Location of Construction: 1179 Washington Ave	Owner Name: Russell Martha A	Owner Address: 1179 Washington Ave	Phone: 797-0678
Business Name:	Contractor Name: Owner	Contractor Address: 1179 Washington Ave Portland	Phone: 2077970678
Lessee/Buyer's Name	Phone:	Permit Type: Additions - Multi Family	Zone:

Dept: Zoning	Status: Approved	Reviewer: Jeanine Bourke	Approval Date: 06/24/2004
Note:			Ok to Issue: <input checked="" type="checkbox"/>
1) This property shall remain a two family dwelling. Any change of use shall require a separate permit application for review and approval. ***NOTE*** THE CURRENT OWNER DOES NOT USE THE ACCESSORY HOME OCCUPATION APPROVAL GRANTED 3/22/99, THIS PROPERTY IS STILL A LEGAL TWO FAMILY.			
Dept: Building	Status: Approved with Conditions	Reviewer: Jeanine Bourke	Approval Date: 06/24/2004
Note:			Ok to Issue: <input checked="" type="checkbox"/>

REVISIONS	
CODE: 9999	
TOWN: PORTLAND	
DATE: 20 MAY 04	
SCALE: AS NOTED	
DRAWN: T.J.F.	
TITLE: BUILDING SECTIONS	
FILE: 04-0073	
SHEET: A3

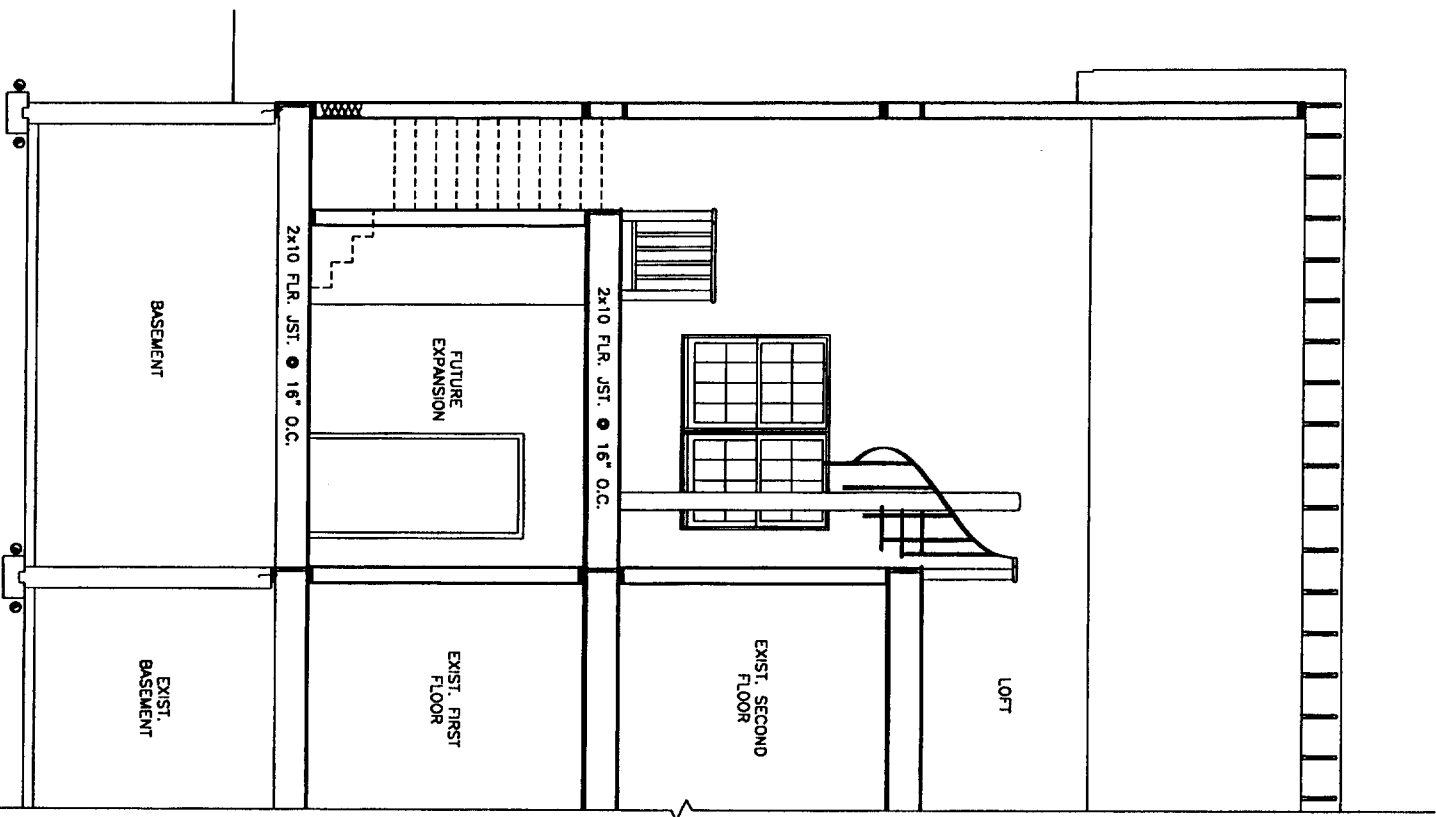
1) The design load spec sheet for the engineered beam(s) must be submitted to this office. The design of the spiral stairway must be submitted to this office.
